**Consultation Response from KC,
Lead Local Flood Authority****2026/91034 University of Huddersfield, Queensgate, Huddersfield, HD1 3DH****Discharge of details reserved by conditions 3, 4, 5, 6 (drainage), 7 (Phase II Site Investigation) on previous permission 2026/90009 for provision of new landscaping scheme on the site of the former faith centre building together with extended delivery area and turning circle and associated works****Date Responded: 06/05/2026.****Responding Officer: Martin Stephenson****Responding Ref: 1****Previous response by the LLFA**

Discharge of Drainage Conditions

Documents reviewed by the LLFA:

Drawing Title  
PROPOSED DRAINAGE

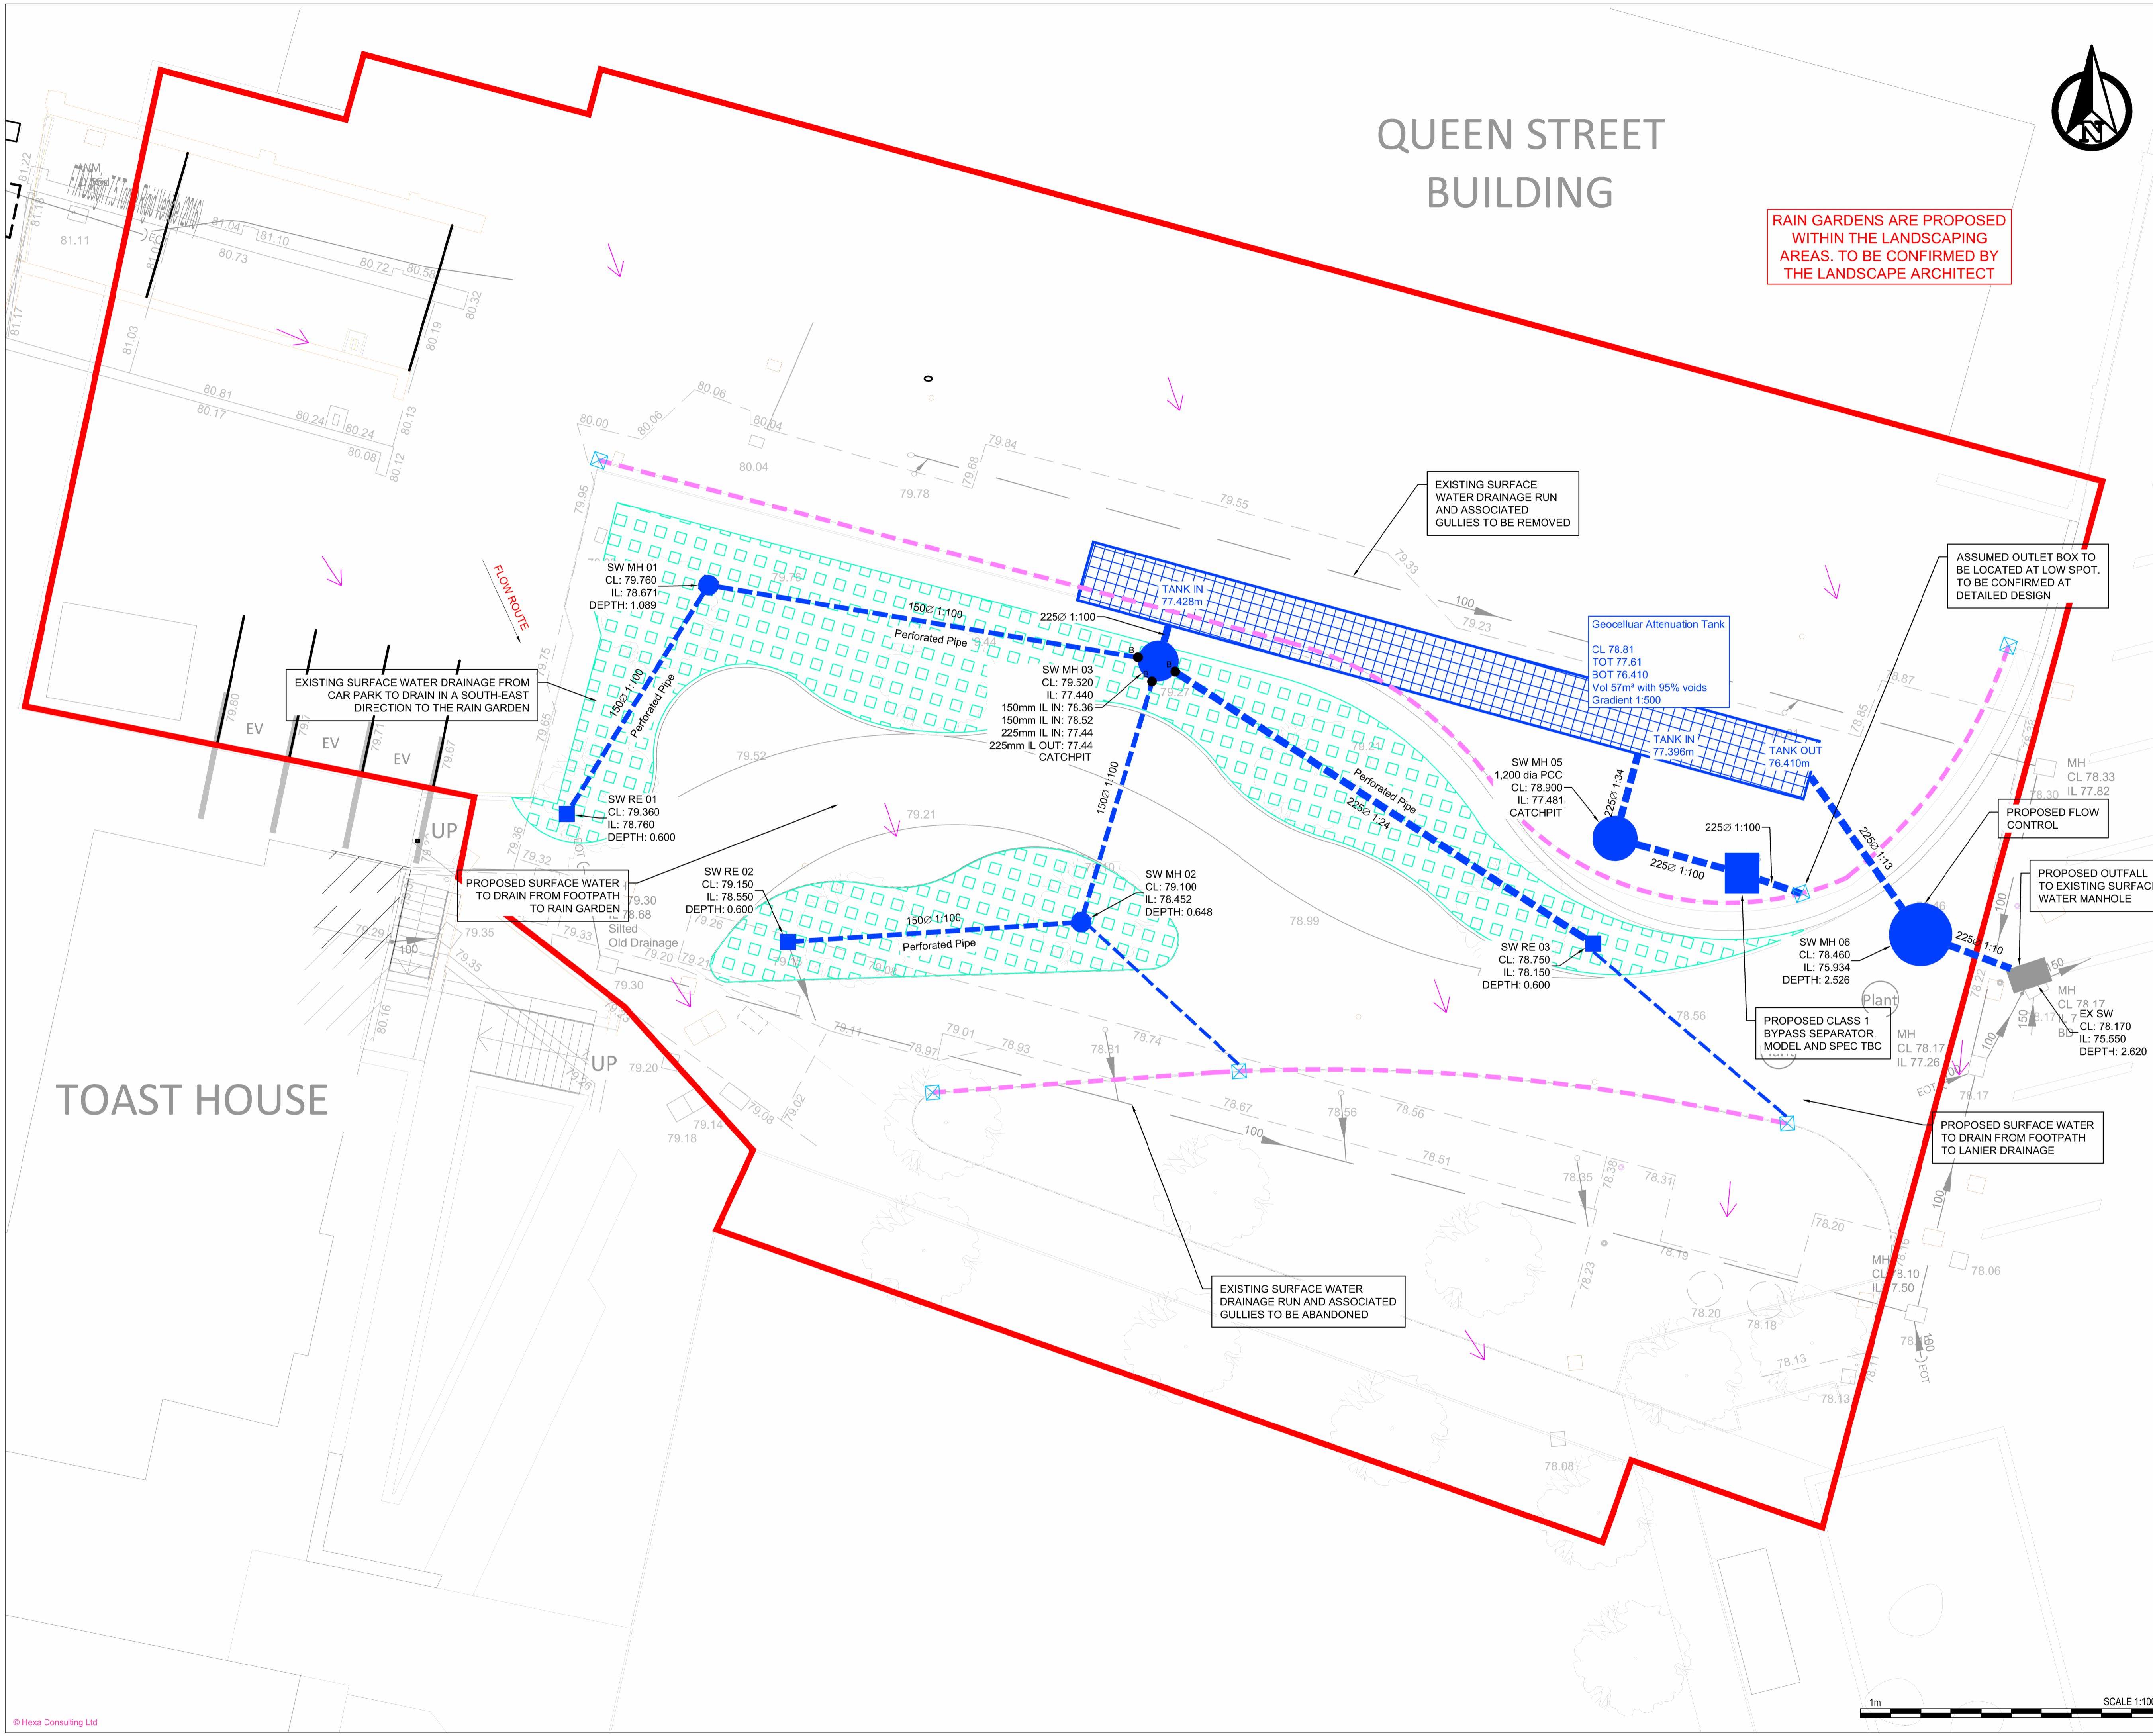
The Proposed Drainage drawing does not indicate the design parameters of the proposed flow control device (design flow rate, design head, outlet diameter).

In addition, no details of the attenuation tank dimensions/depth are shown together with the means of access into the tank for inspection and maintenance compliant with CDM Regulations together with a Maintenance Plan for the tank & flow control device (as stated in the Decision Notice).

The flow control device and tank details need to be shown on the drawing to ensure the correct device/tank is installed on site. Therefore Condition 3 **cannot be** discharged.

The LLFA confirms that the flood routing shown on the Proposed Drainage drawing is accepted, therefore Condition 4 **can be** discharged.

The Proposed Drainage drawing does not indicate the model of the proposed oil separator (note that "TBC" is not acceptable at this stage). This need to be shown on the drawing to ensure the correct device is installed on site, therefore Condition 6 **cannot be** discharged.
